Re: PA23-018 – Pilchuck Rentals CUP – Technical Review 1  
Job. No.: 21c-4287

To: Amy Hess  
City of Marysville – Community Development Department  
501 Delta Avenue  
Marysville, WA 98270

### **Technical Review 1**

1 NORTH ELEVATION
SCALE: 1/8" = 1'-0"

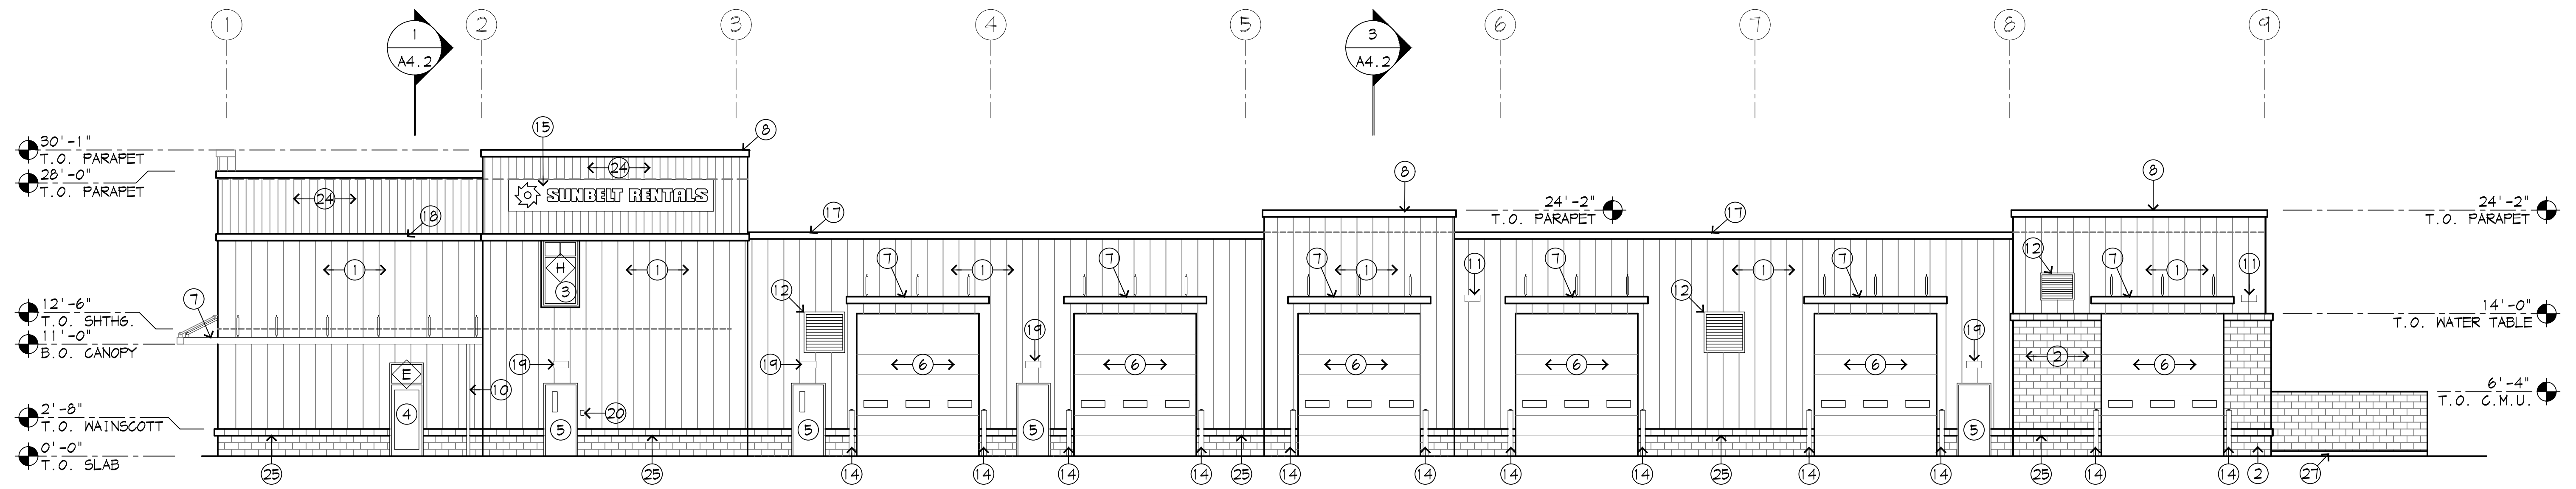
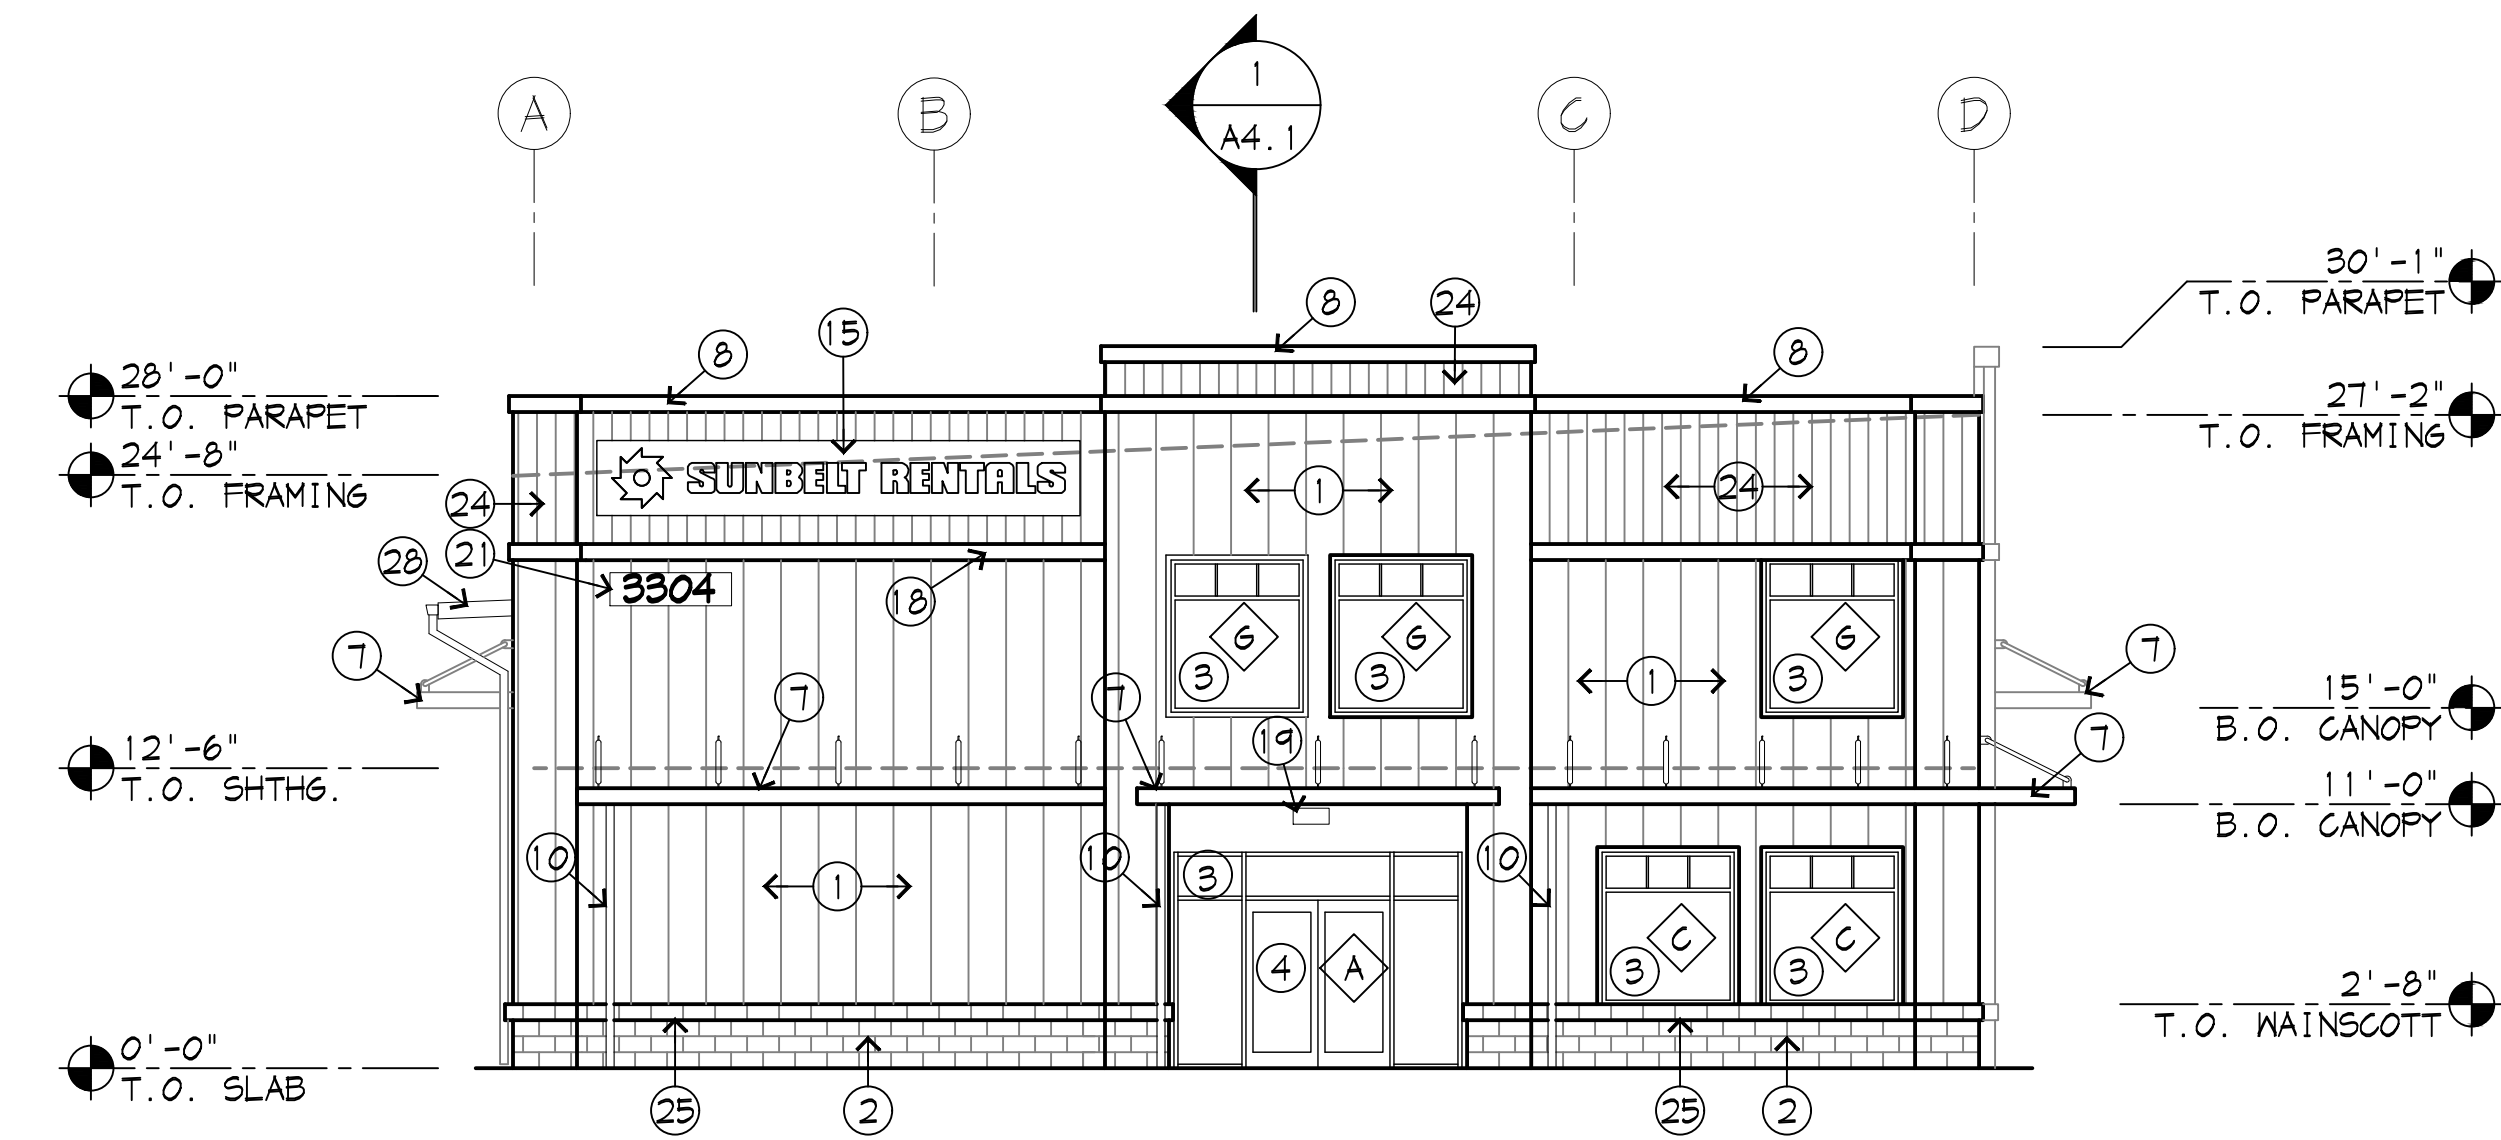
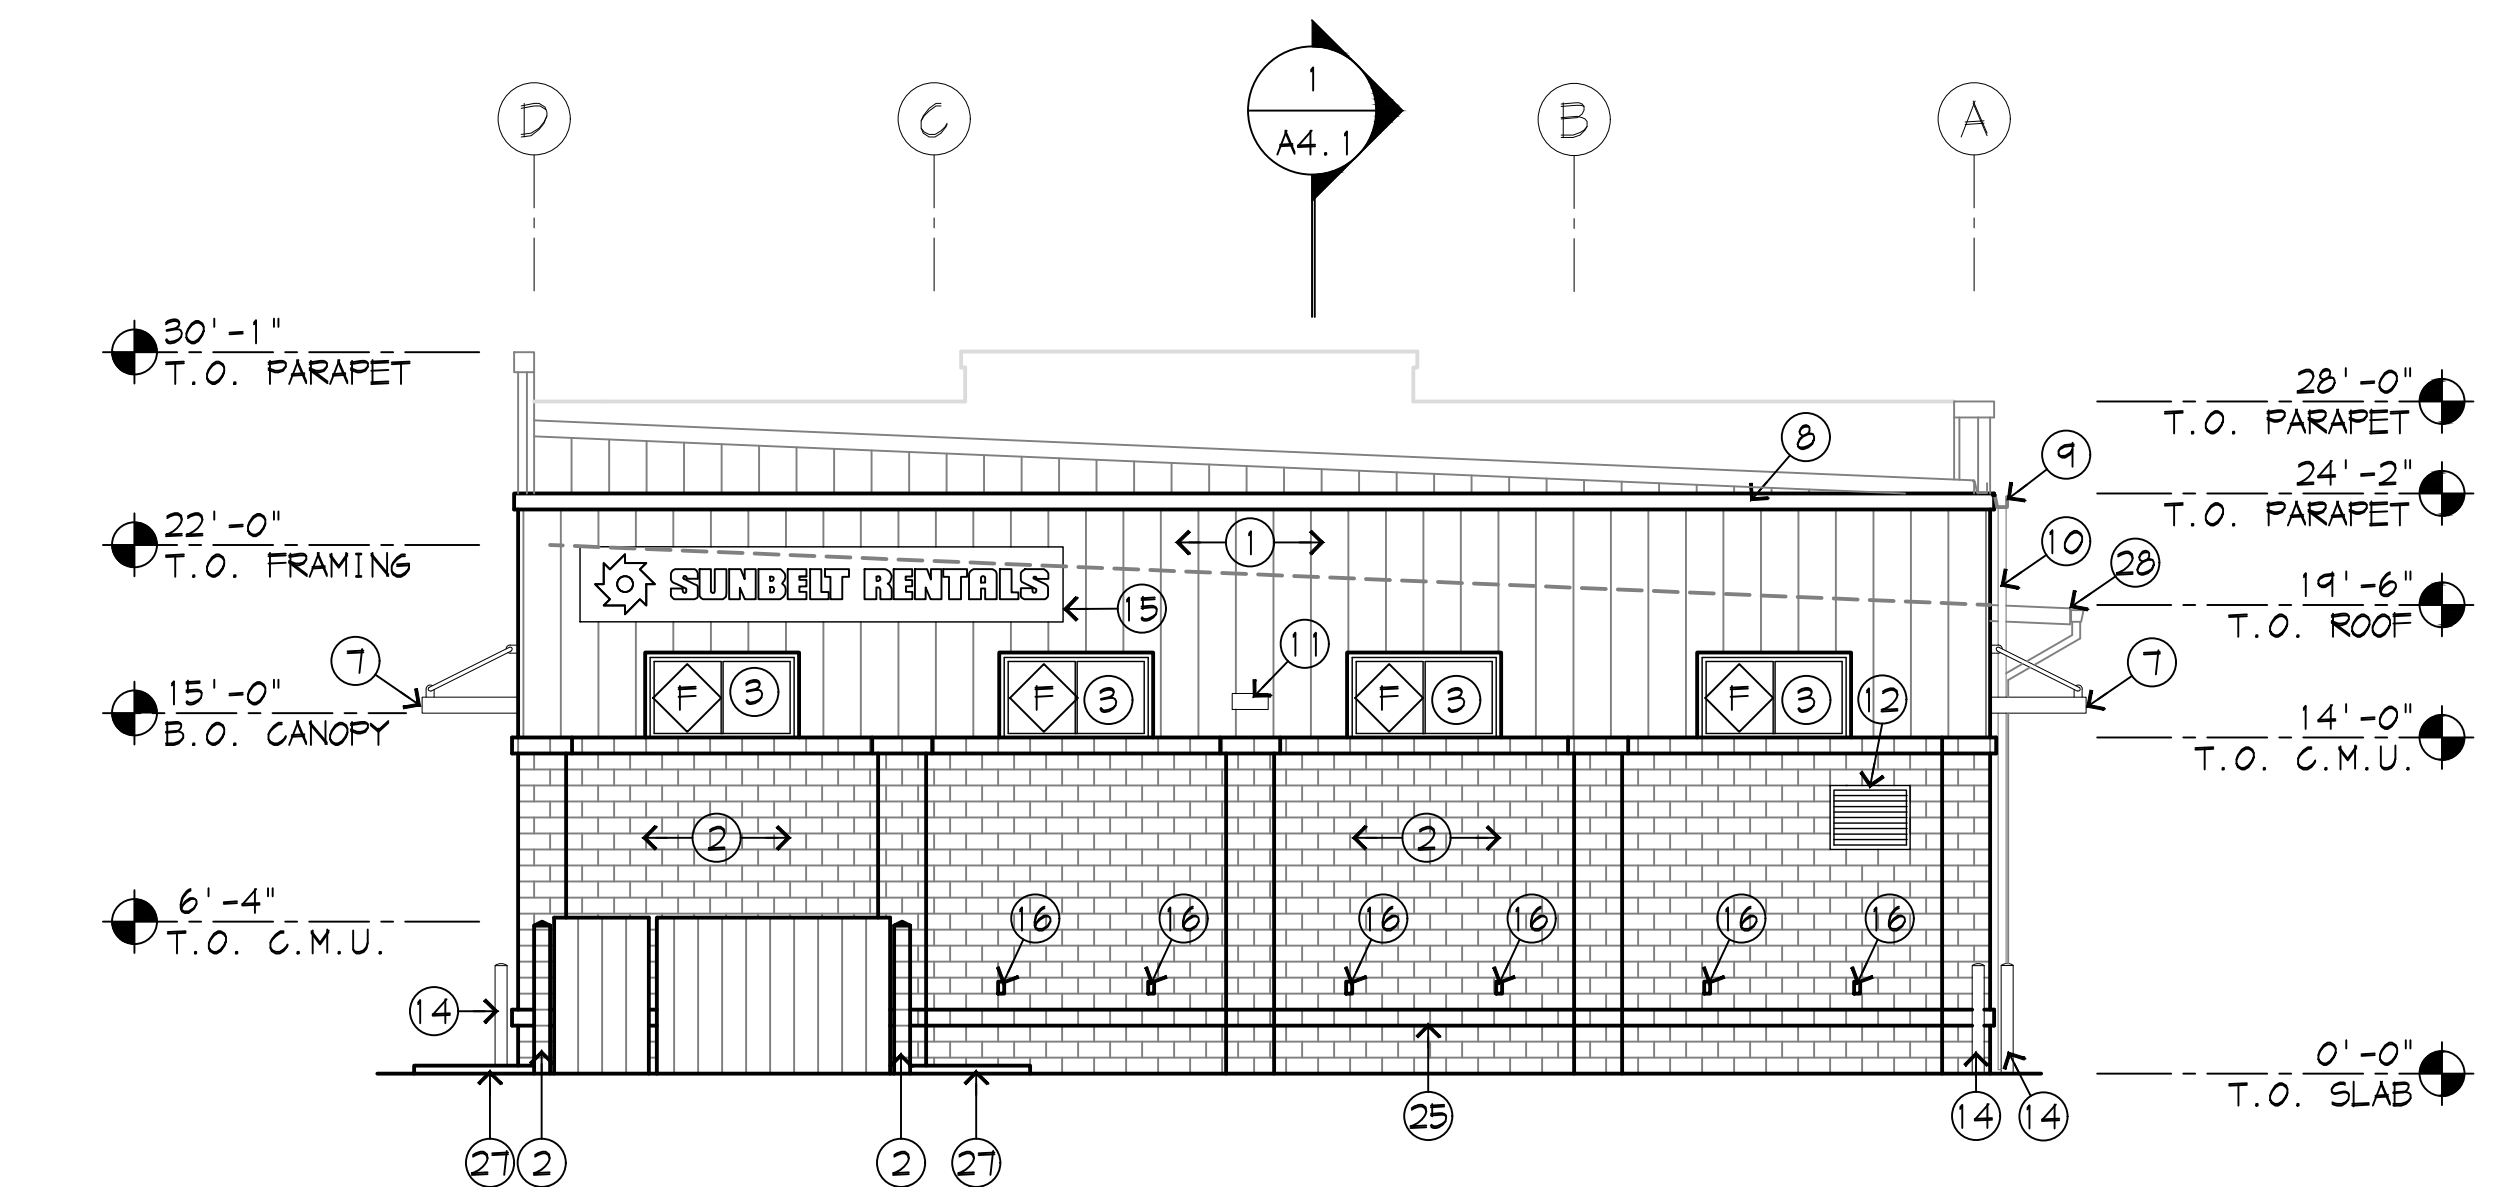
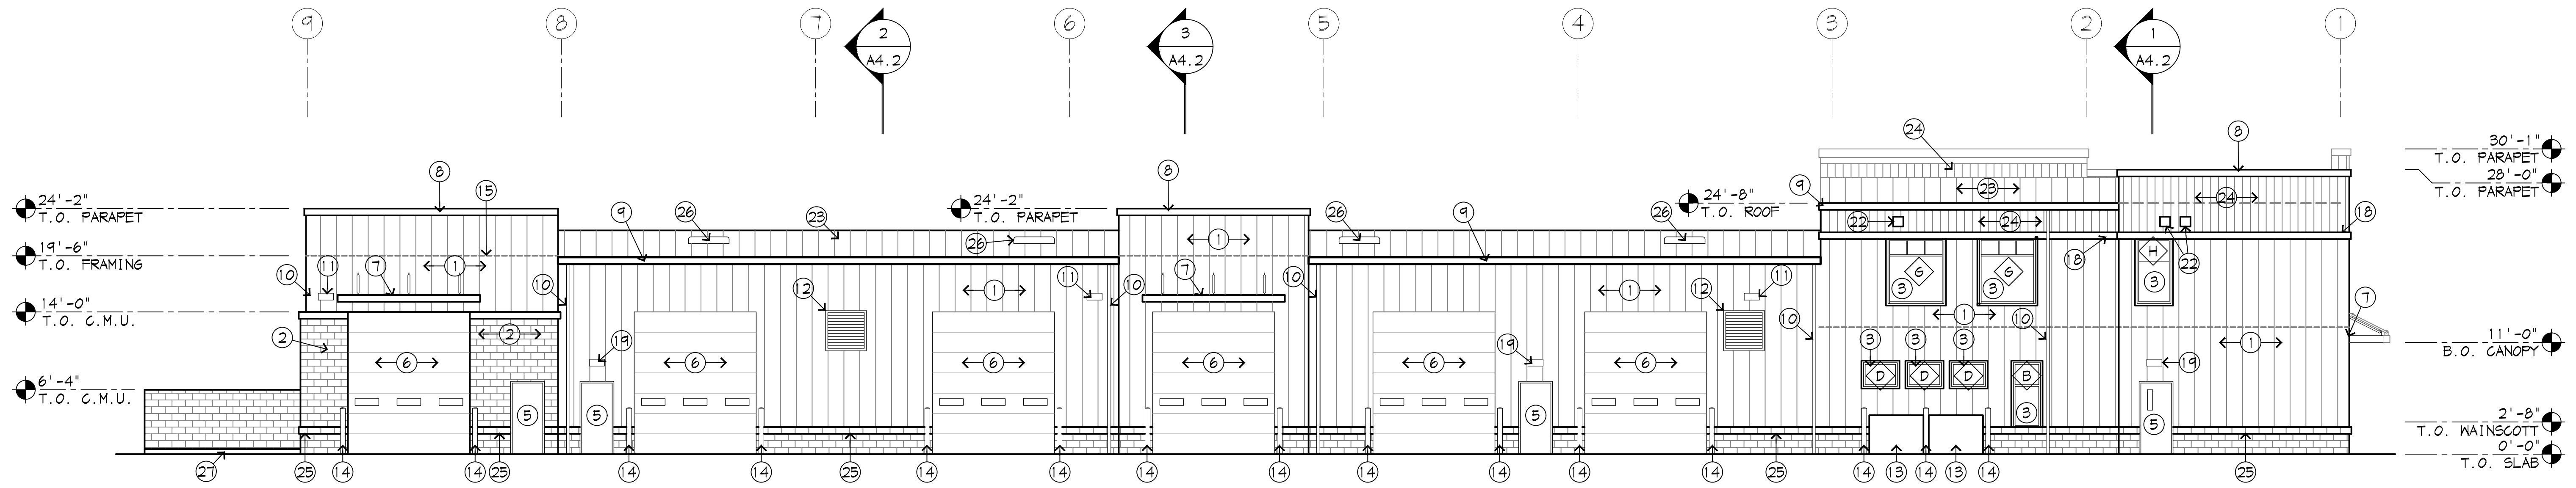
The west elevation meets the definition of a blank wall and is required to include one or more of the treatments outlined in MMC 22C.020.250(11).

MMC 22C.020.250(7)(a) – Façade modulation. It does not appear that any façade modulation is proposed. Please revise to meet the façade modulation requirements in this section.

MMC 22C.020.250(7)(b) requires street front articulation. Please include at least two of the options listed in this section.

MMC 22C.020.250(7)(d) – Roofline Modulation. It does not appear that there is sufficient roofline modulation to meet these standards. Please revise accordingly.

MMC 22C.020.250(9)(a)-(c) – Building Design details. Additional elements are needed to meet these standards. This could include, but is not limited to, extending the brick shown along the lower portion of the building and wrapping it around all elevations, varying the color/material to provide some actual interest, and incorporation of more varied high quality materials.

MMC 22C.020.250(10) – Building Materials. Metal siding must have visible corner moldings and trim...and incorporate masonry stone, or other durable permanent materials within two feet of ground level. This is required on all frontages visible from public streets (north, west, and east). Metal siding must also incorporate multiple colors.

*The architect has worked with Amy Hess of the City of Marysville Planning Office to create building elevations/ plan layout that meet all the requirements stated above. Amy Hess gave her approval in an email sent on 11/17/23.*
